Recommendation Report for Planning Permission for Works or Extension to a Dwelling

REF NO: AL/41/26/HH

LOCATION: Karenza
Hook Lane
Aldingbourne
PO20 3TB

PROPOSAL: Single storey side extension, new chimney, roof extension including raising of the ridge height to facilitate conversion of loft to habitable use including 2 No. front dormers and new front canopy.

No.	Revision/Issue	Date.
1

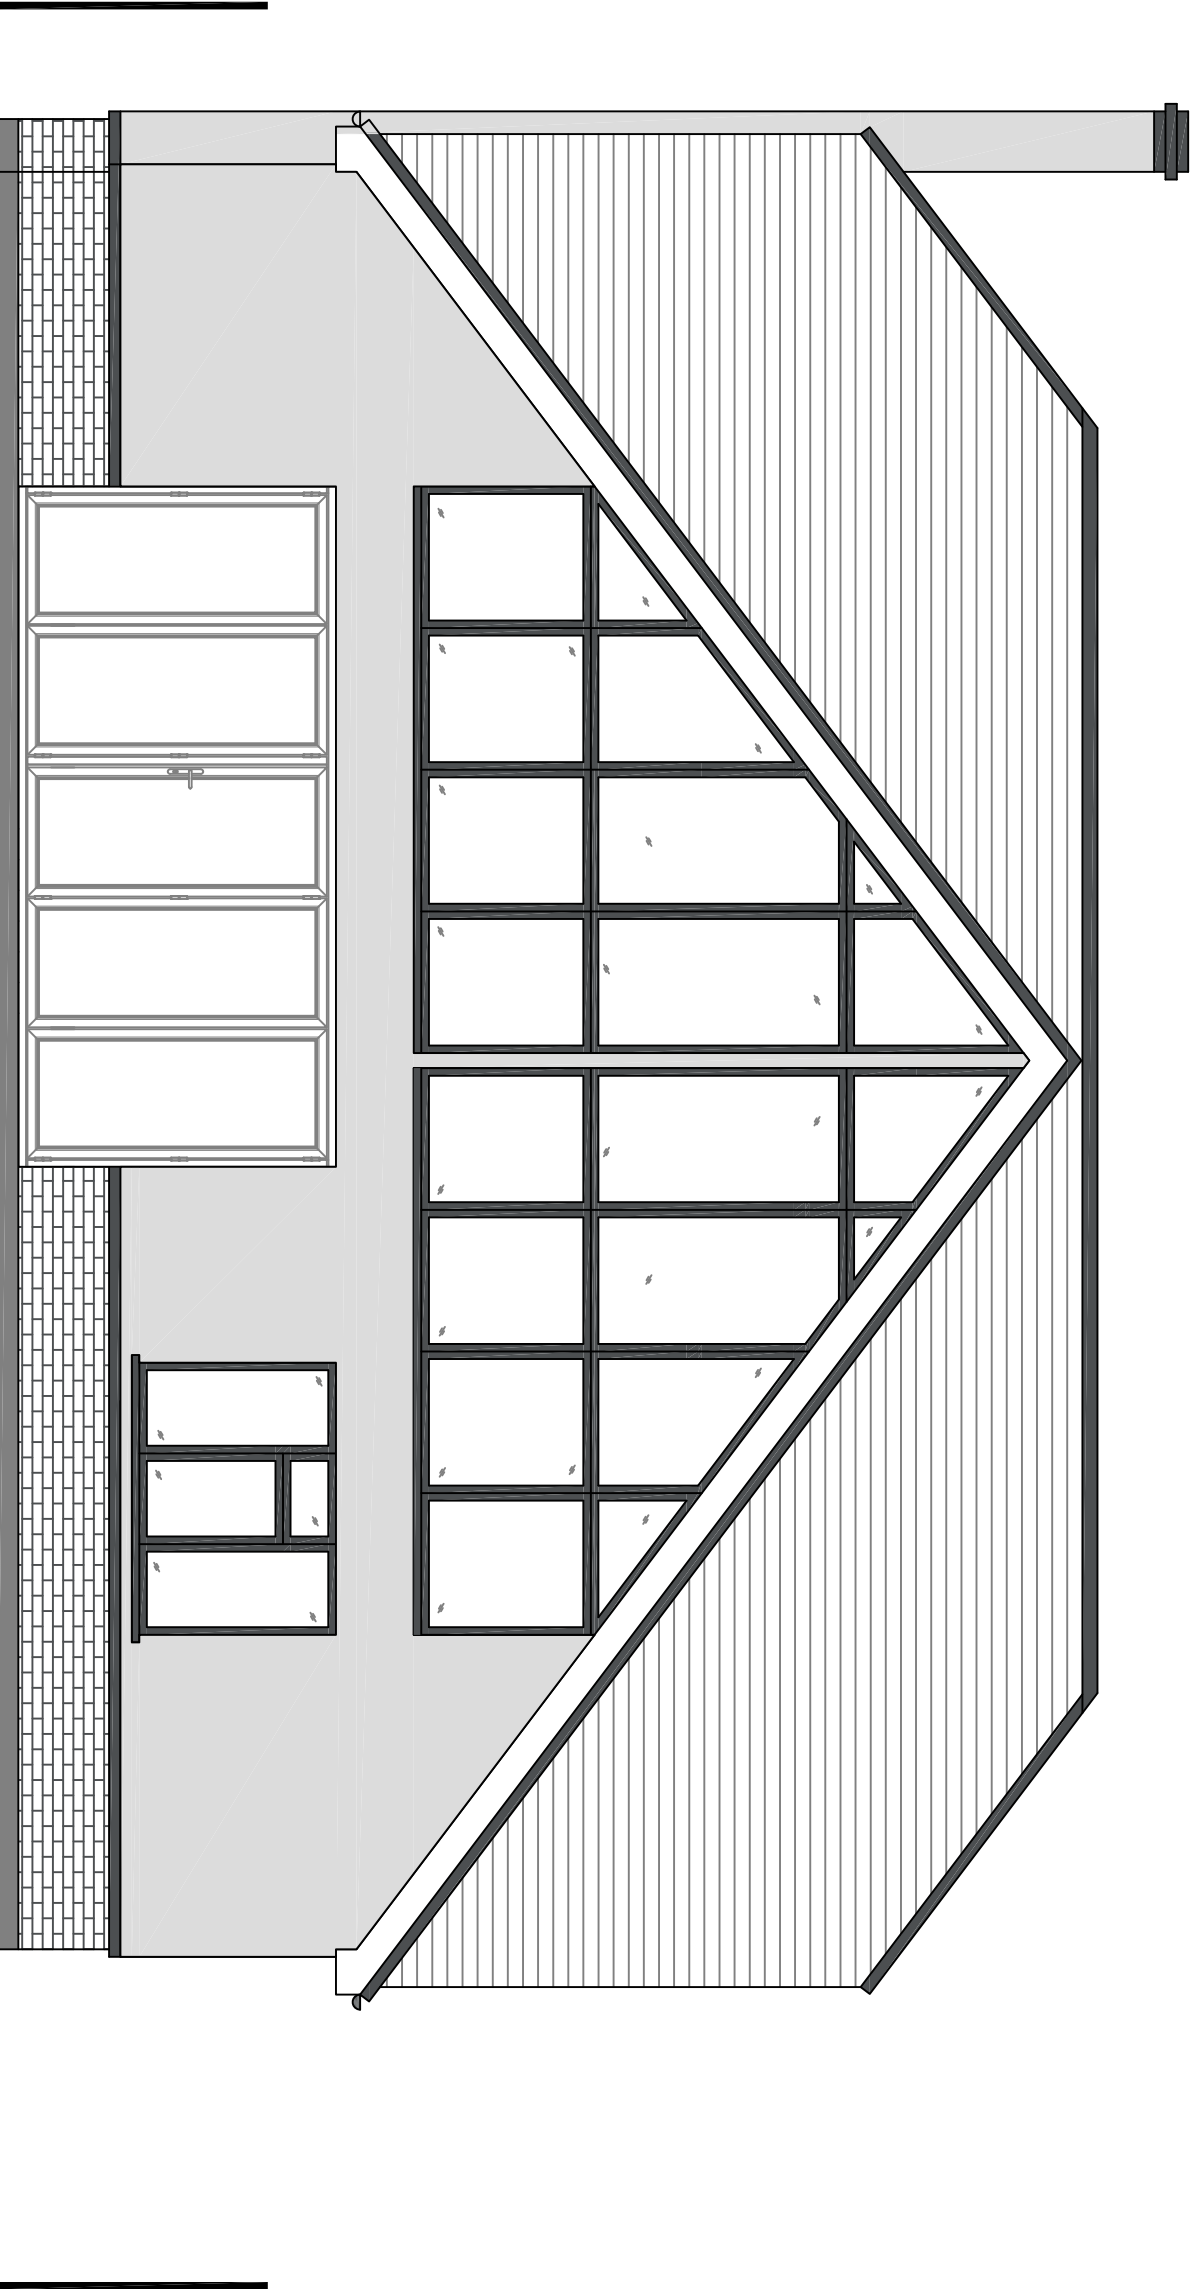
To accommodate a new first floor, it is proposed to raise the roof ridge by 1.7m, to a height of 7.65m. Given the length of the rear garden, the proposal would comply with minimum back-to-back distances of 21m, as described by the ADG. Furthermore, given the existing variation within the wider street scene, the proposed increase in ridge height would not result in harm to visual amenity.

The proposed roof alterations would include the creation of a new rear gable feature, which would span the width of the dwelling following the side extension and be equal in height to the new ridge line. The new roof slopes would slope towards the centre of the dwelling to the front and rear as the ridge line would run from west to east rather than from north to south as existing. The clipped side gables would help reduce the overall bulk following the substantial increase in roof form. Given the existing variation within the wider locality and street scene with regards to roof forms, the proposed alterations to the roof would not result in harm to visual amenity, albeit an increase in bulk and massing of the dwelling.

The new rear gable would include extensive glazing, with the new windows spanning across the whole first floor level, resulting in a contemporary, modern appearance. The locality is not characterised by modern design; there is a distinct rural character. Notwithstanding this, given the siting of the modern gable at the rear of the site, equal in depth to the existing rear wall and 38m from the rear boundary, there would be no undue harm to design or visual amenity.

The ADG advises that dormers should be located symmetrically on the roof slope, avoid flat roof form and be sited away from hips and ridges; The two front dormers proposed would have pitched roof slopes, be set in from the flank elevations by 1.9m and would be set down from the new roof ridge by 0.7m, therefore compliant with ADG standards.

The proposed front porch canopy would project 1.3m beyond the front building line and would have a pitched roof, compliant with ADG guidance for porch / front extensions. Set centrally on the front elevation, between and below the two dormers, the front canopy would be a sympathetic addition.

Proposed First Floor Plan

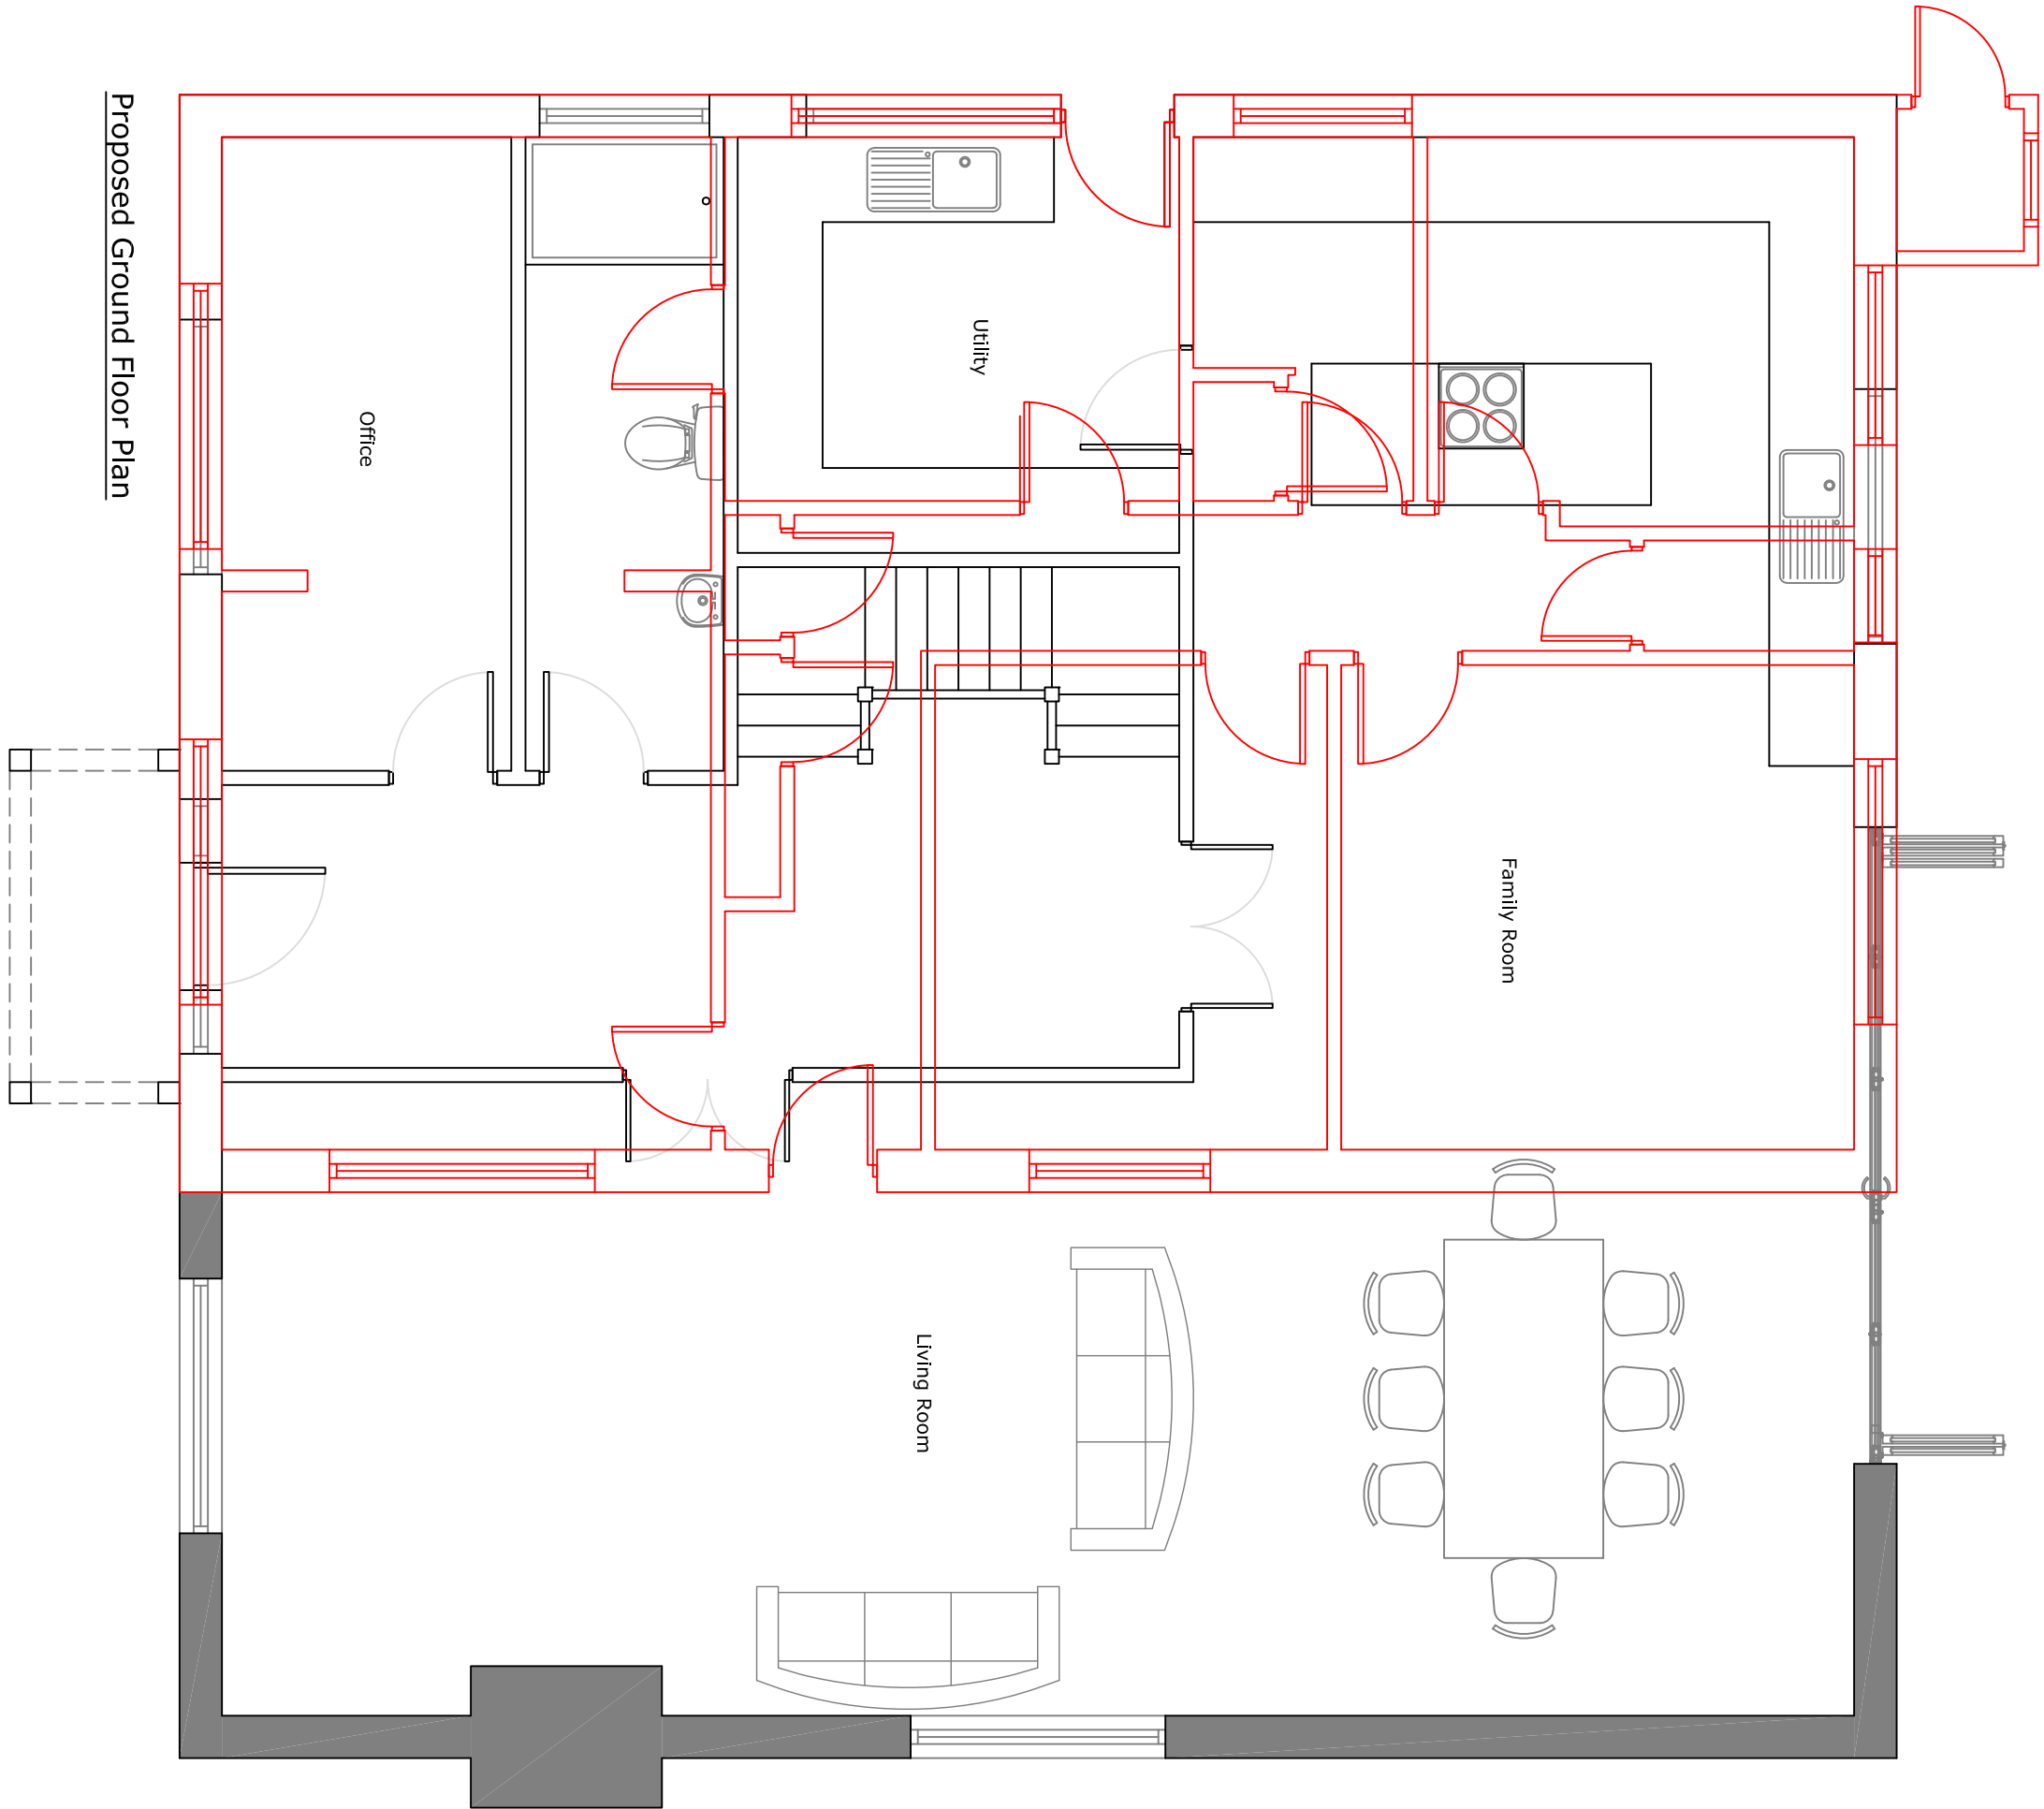
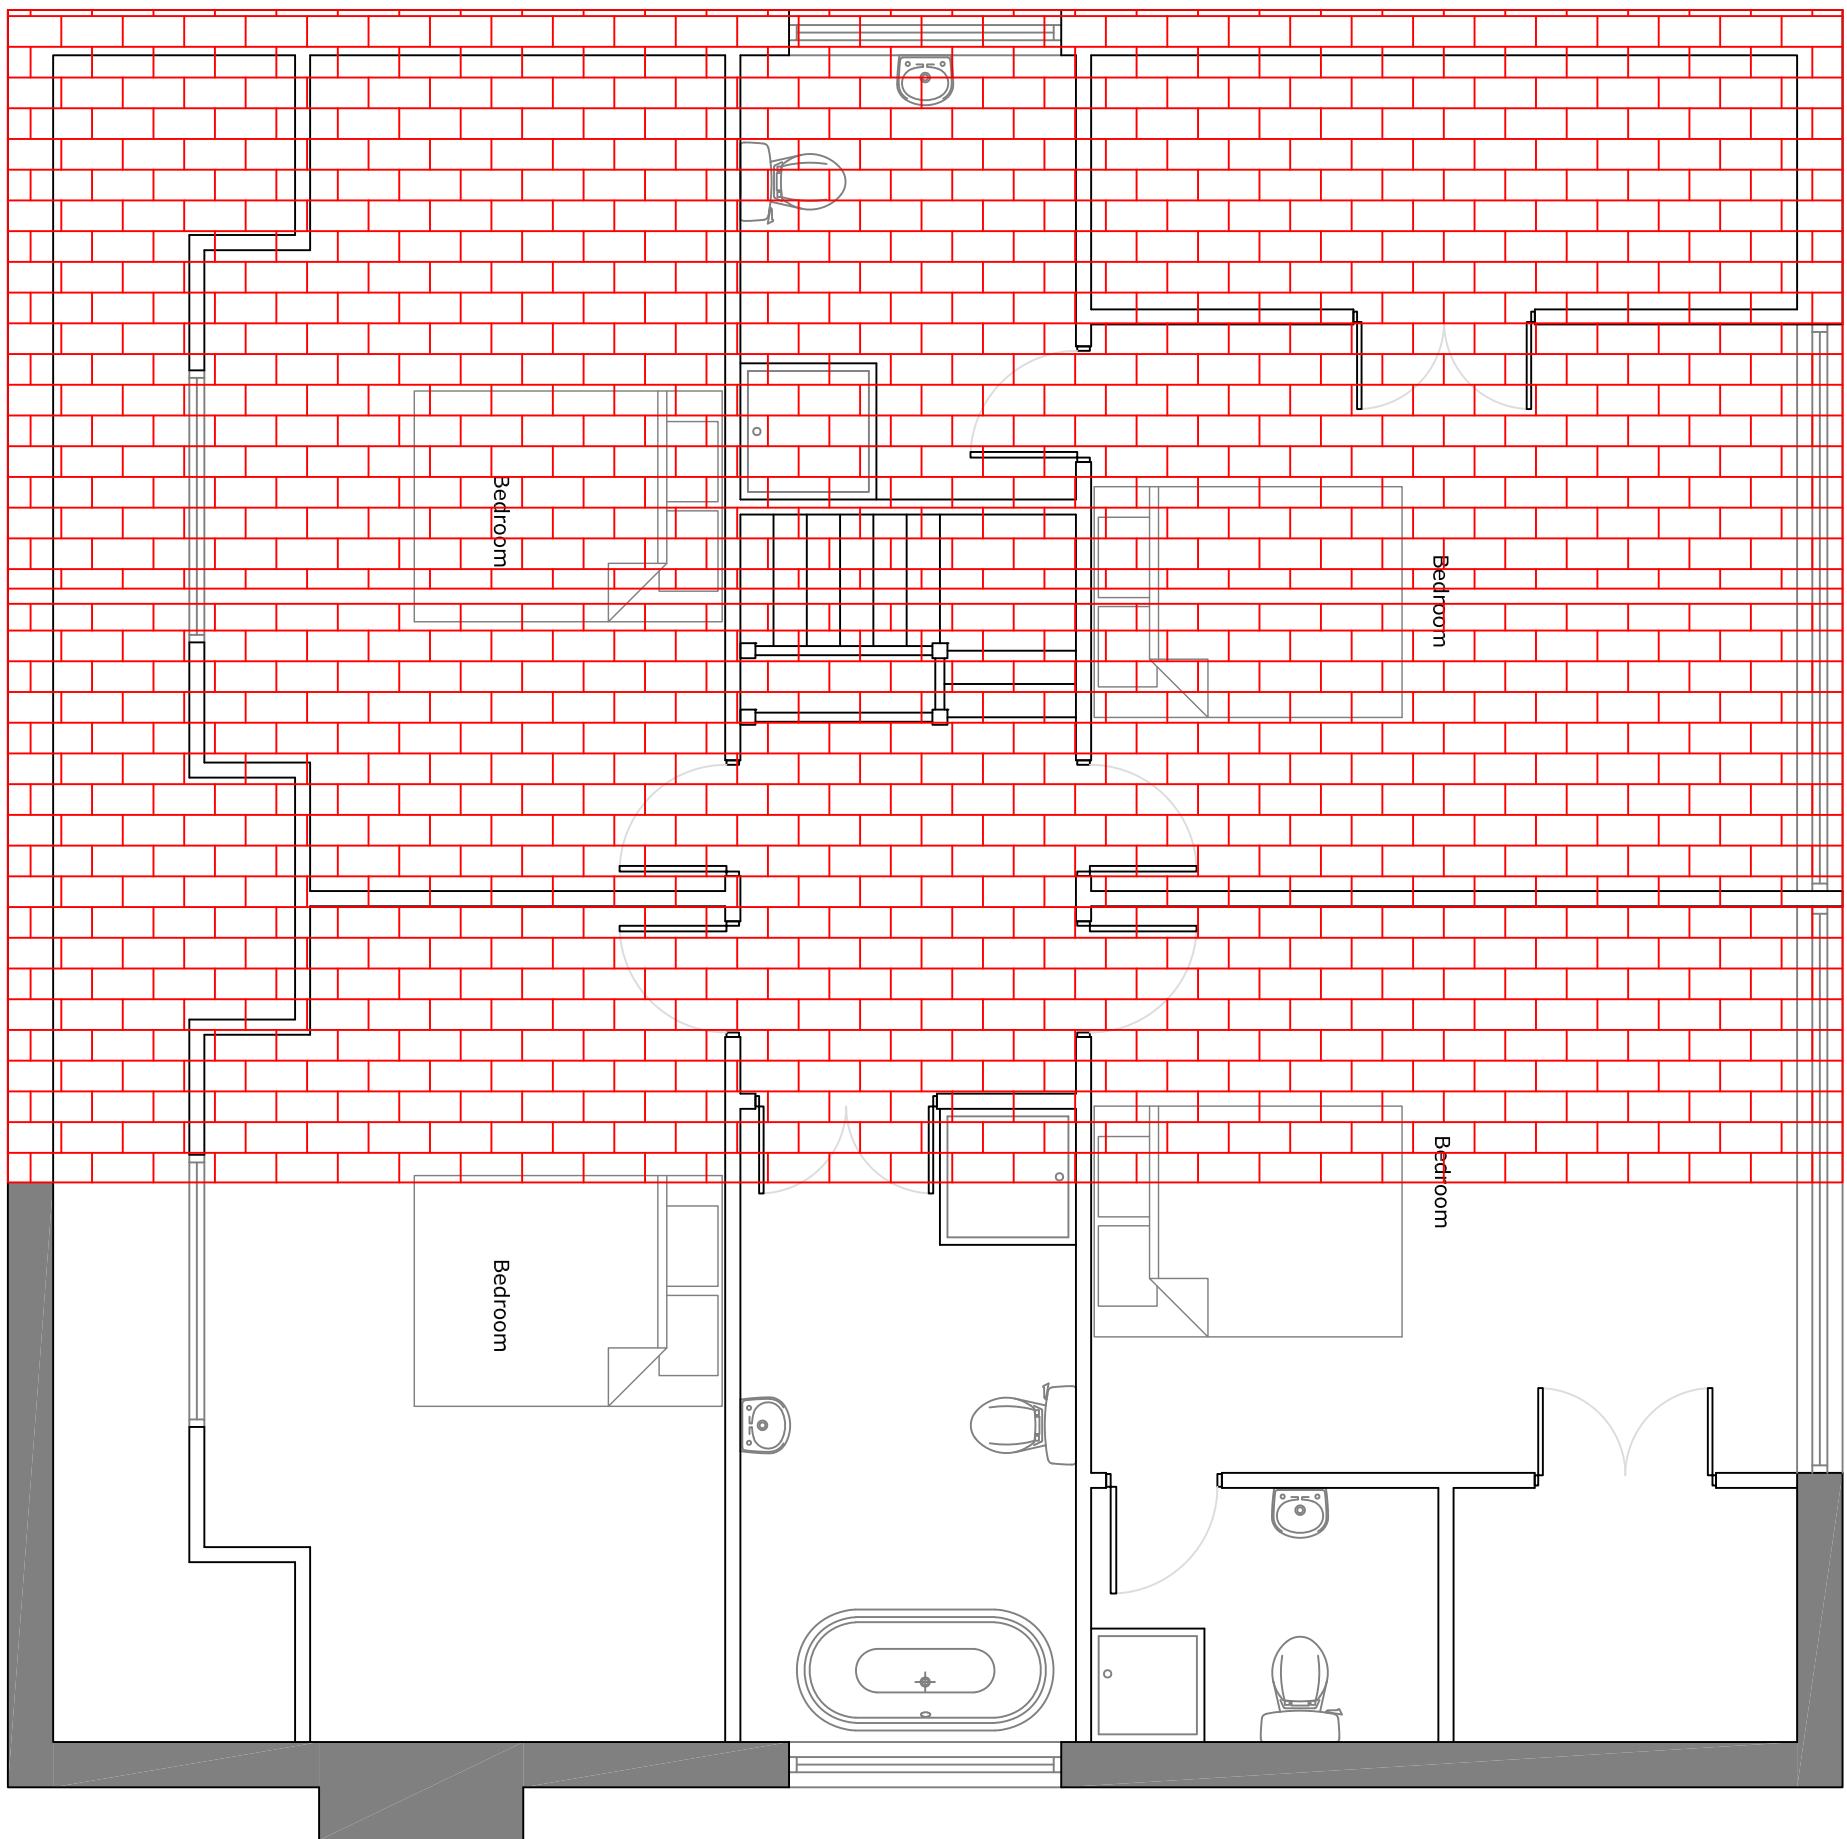
The side windows at first floor level would each serve bathrooms. Given the siting of these windows, it is reasonable to attach a condition to this planning permission to require the first floor side windows to be obscurely glazed and non-opening up to 1.7m from first floor level, to avoid unacceptable overlooking from occurring.

- 5 The windows at first floor level within the eastern and western flank elevations shall at all times be glazed with obscured glass to a level equivalent to Pilkington Level 3 or nearest equivalent standard and be non-openable below 1.7m above finished floor level. This arrangement shall be permanently retained thereafter.
